CROWN TRADING CENTRE – DESIGN ADJUSTMENTS
PLANNING ISSUE

INTRODUCTION

During the detailed design of the buildings, small adjustments have been made in order to reflect emerging legislation (notably fire legislation), introduced through quality improvements in building products, correct some small inconsistencies in the consented scheme, and as a result of feedback from third parties (notably the police). During these changes we have at all times maintained the vision established in the consented scheme. This report describes as simply as possible what those changes are.

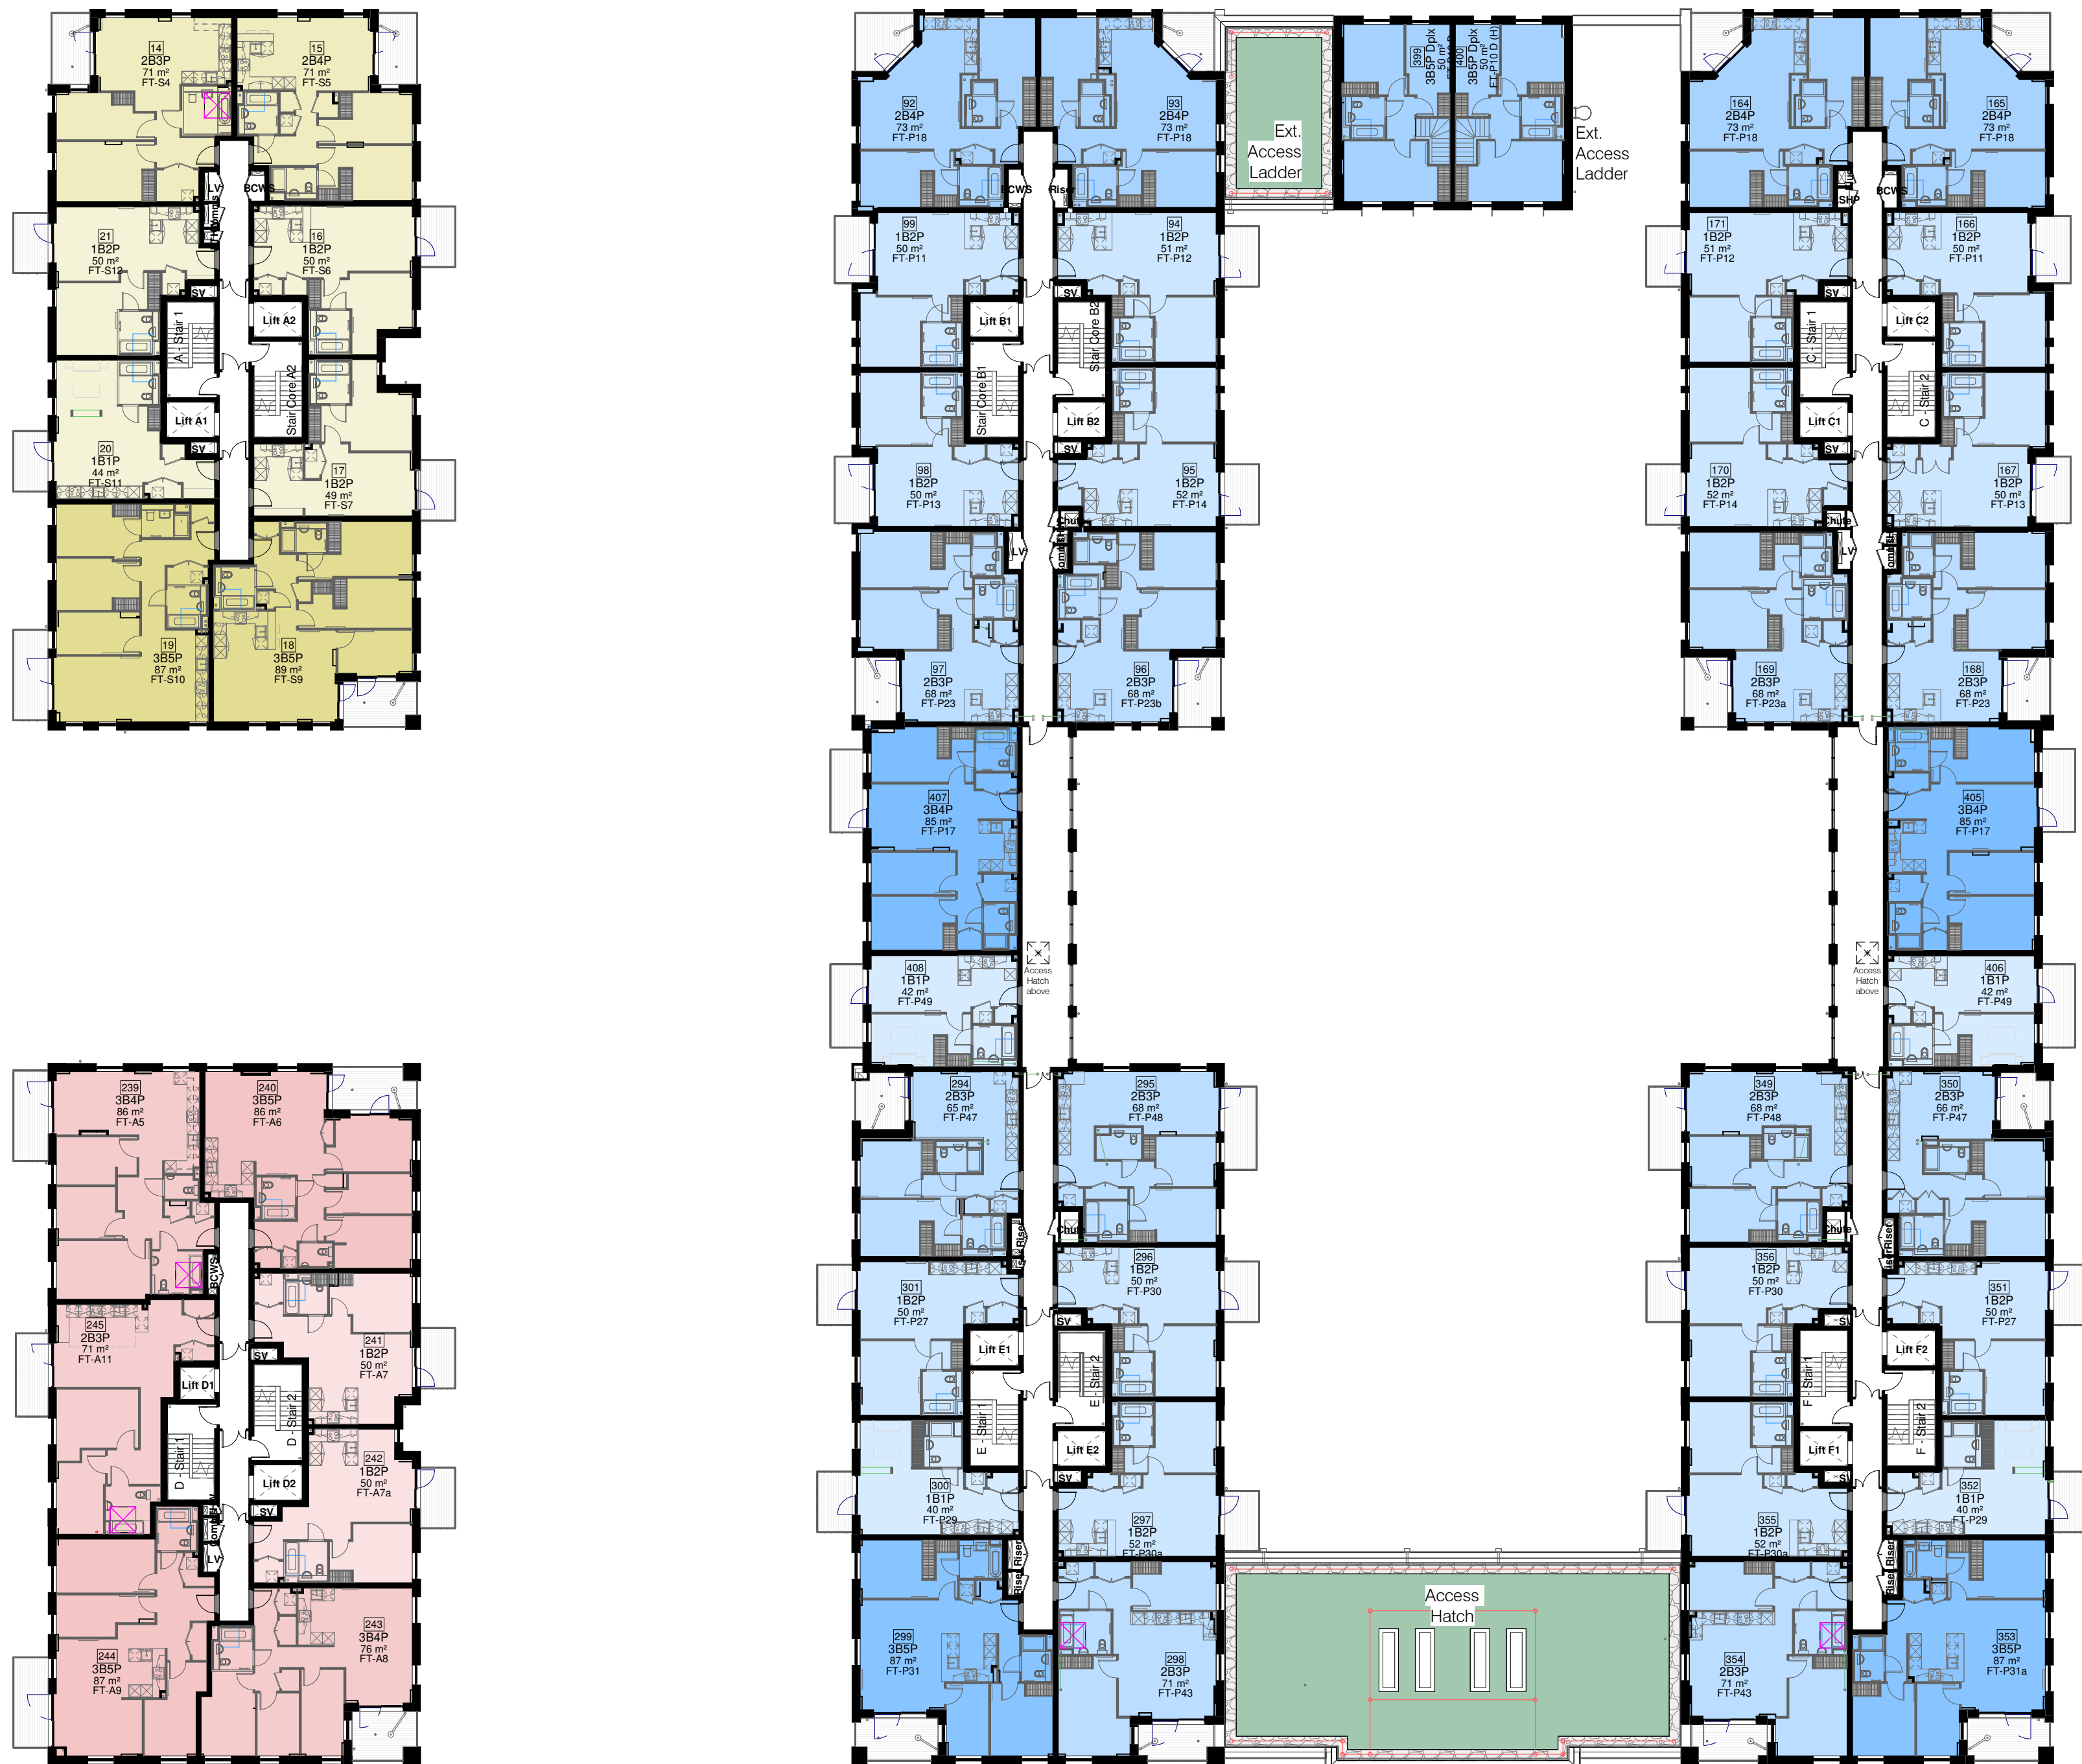
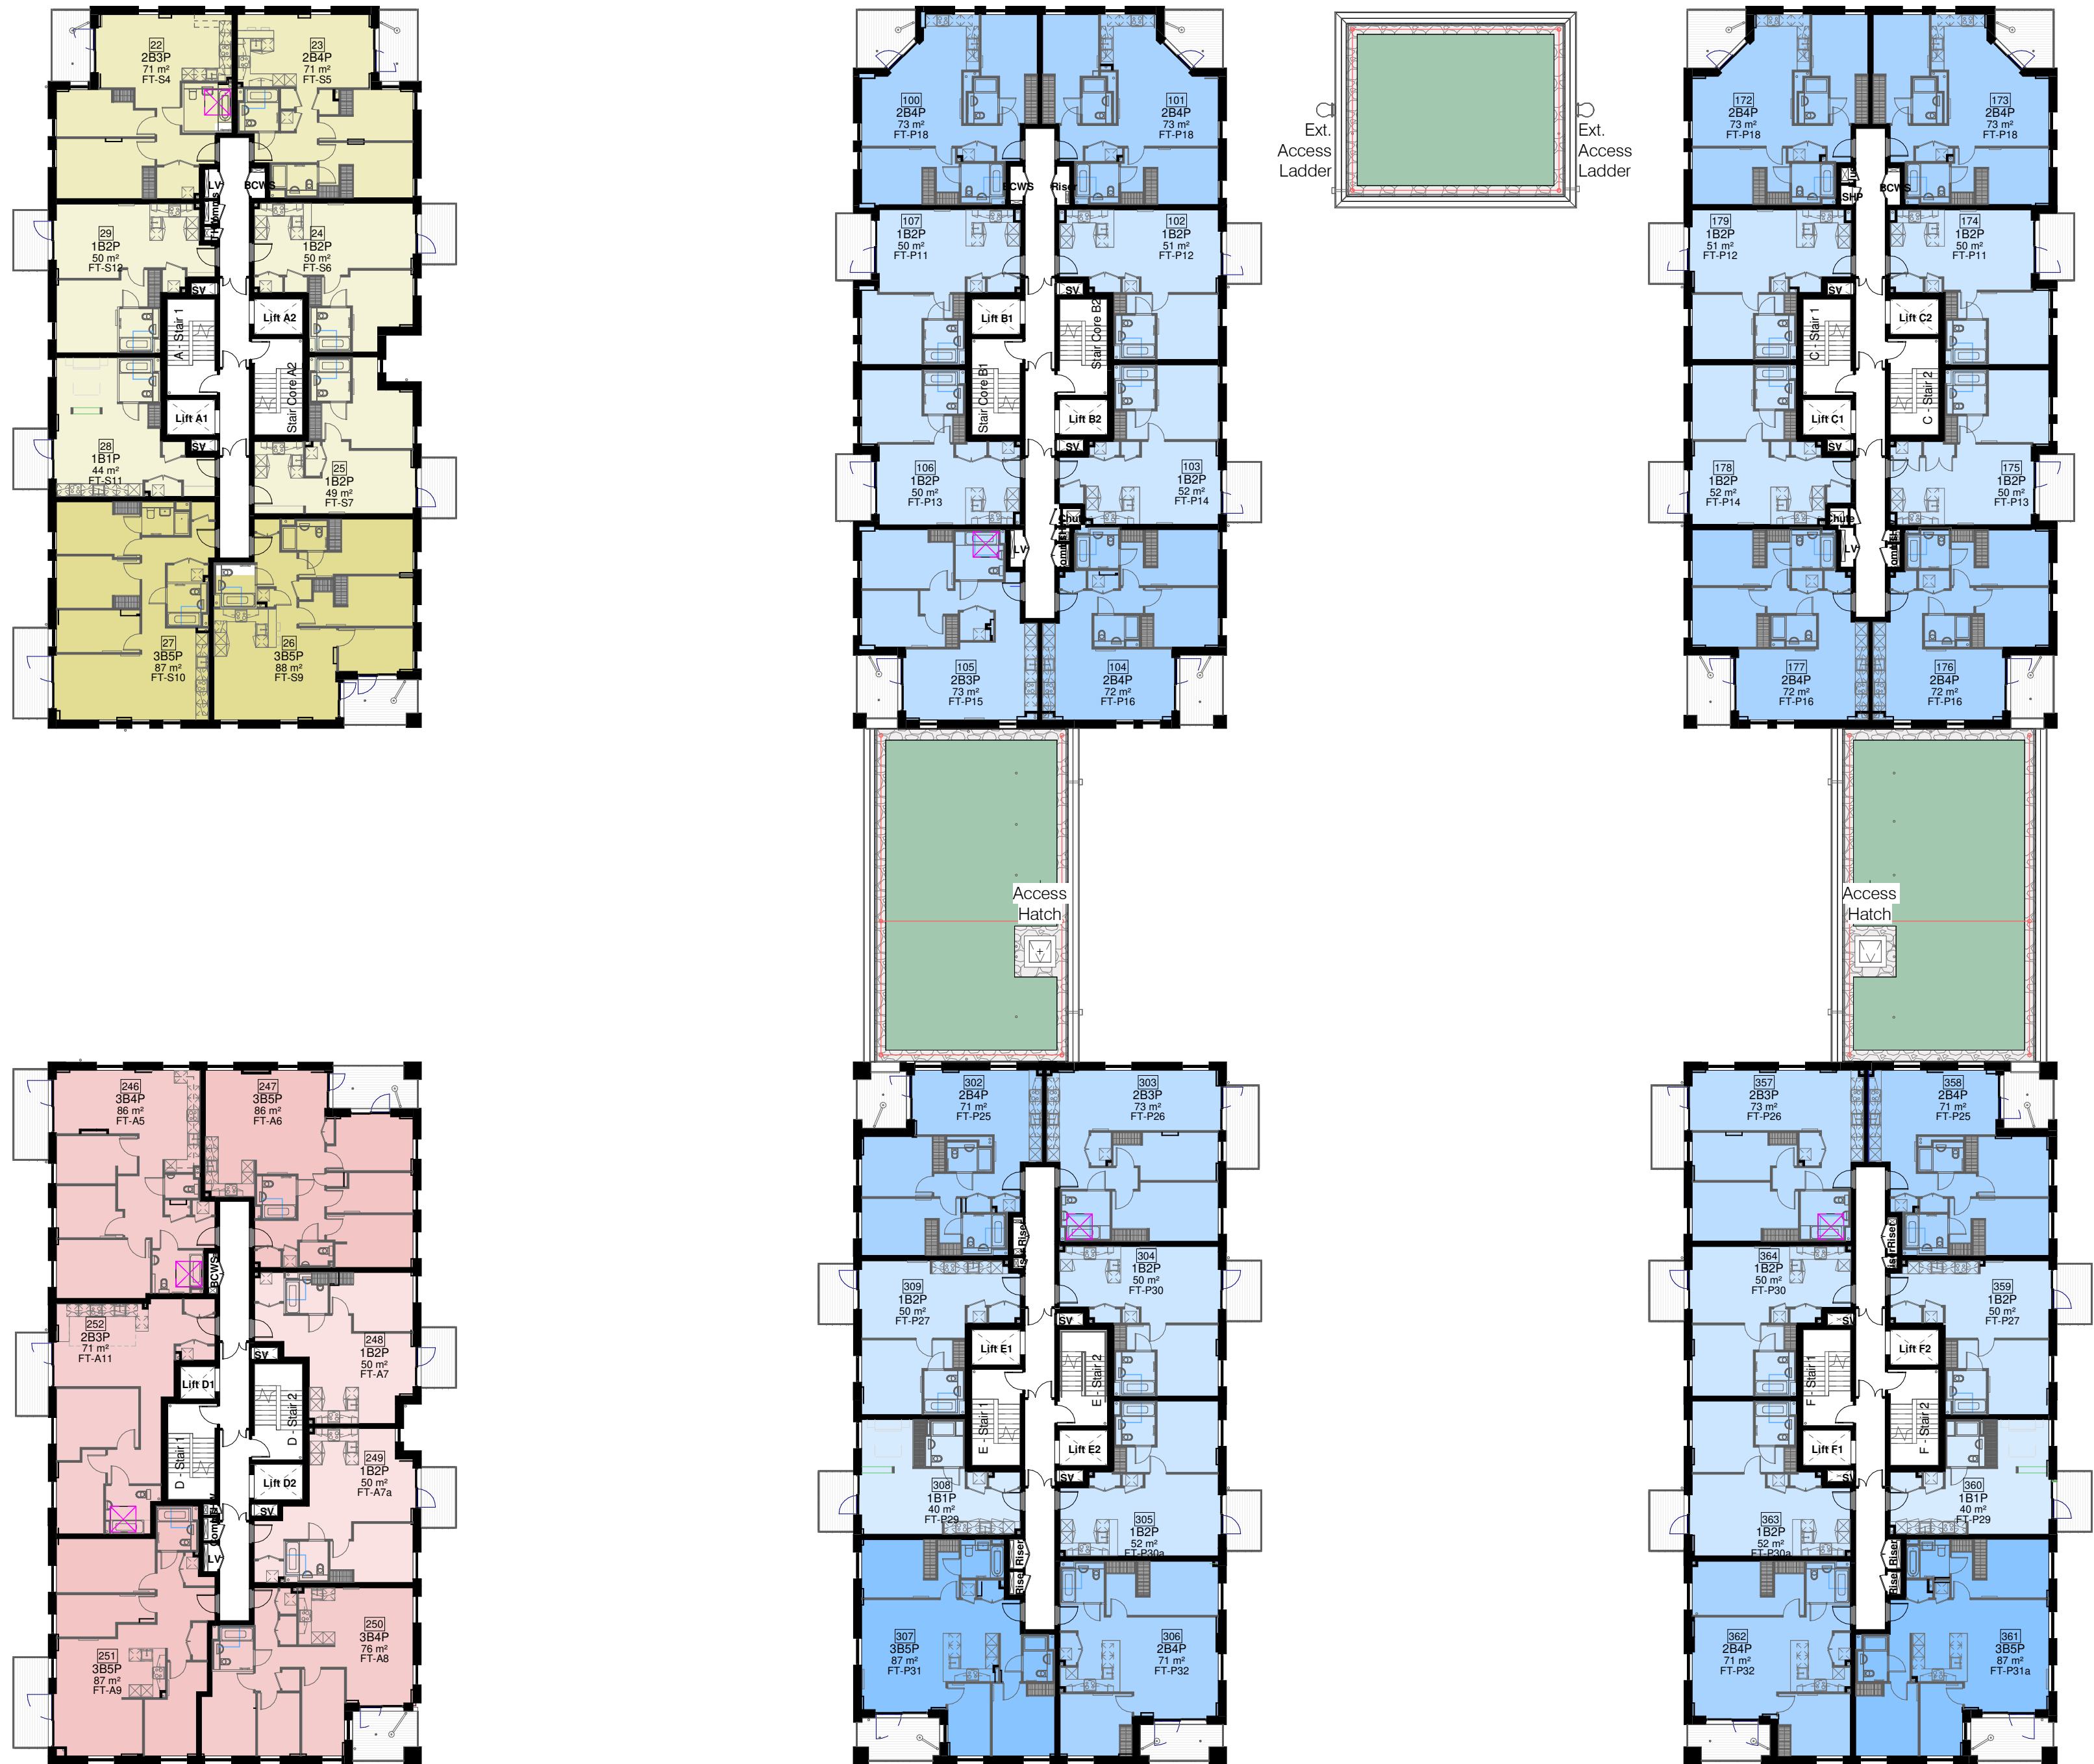
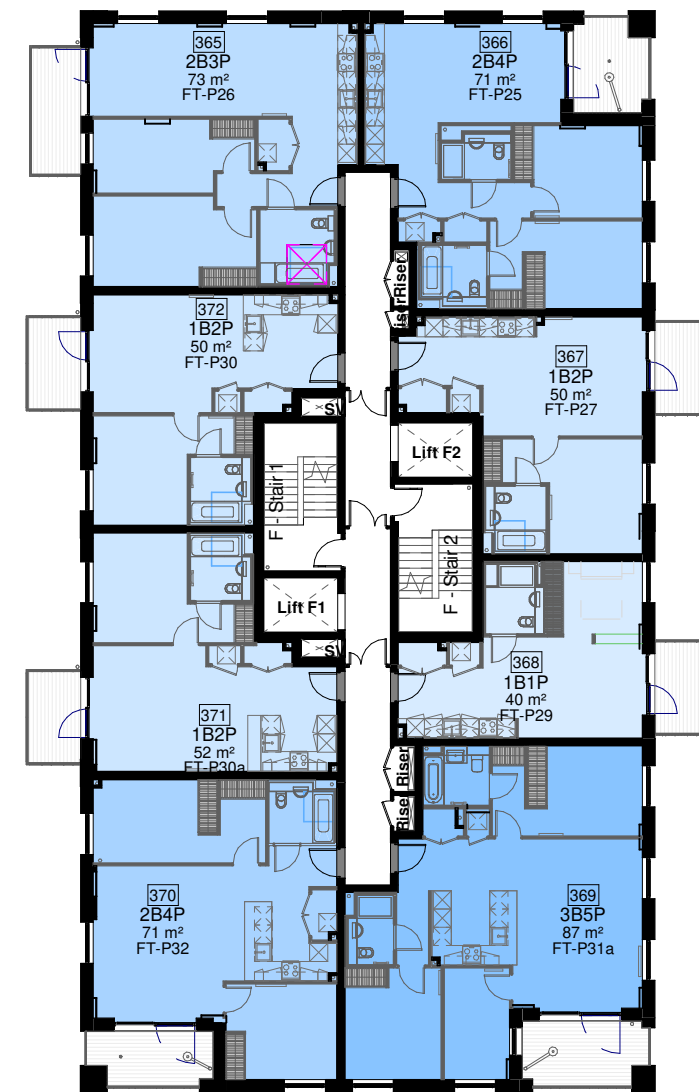
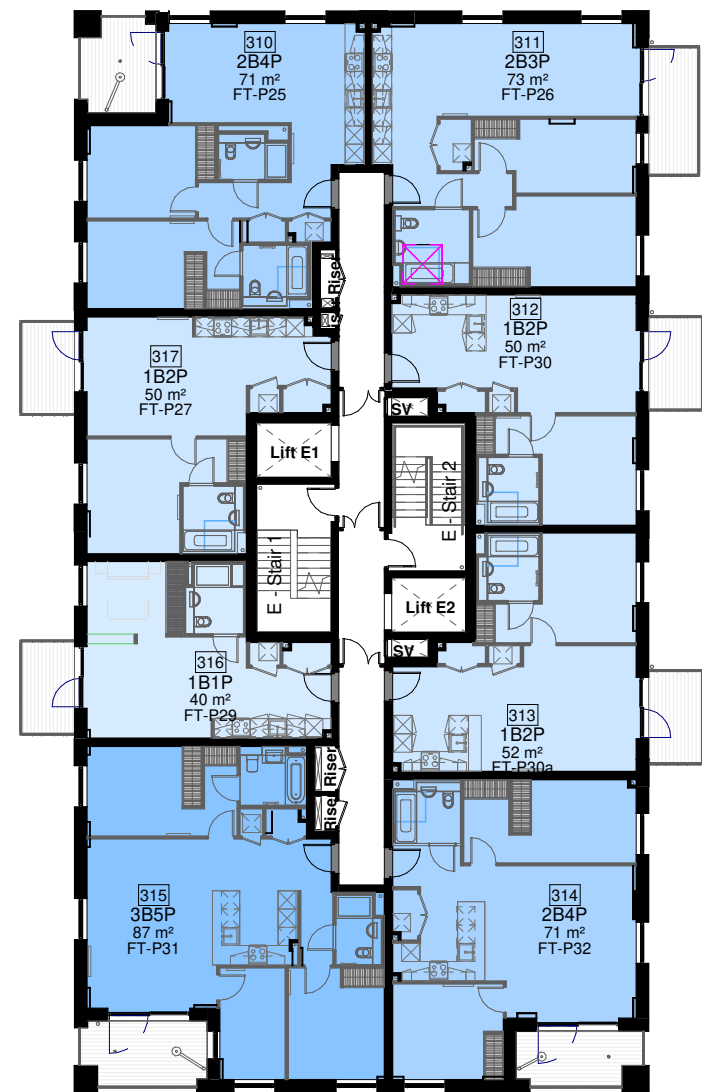
1. Lift and Stair positions amended to comply with emerging fire regulations
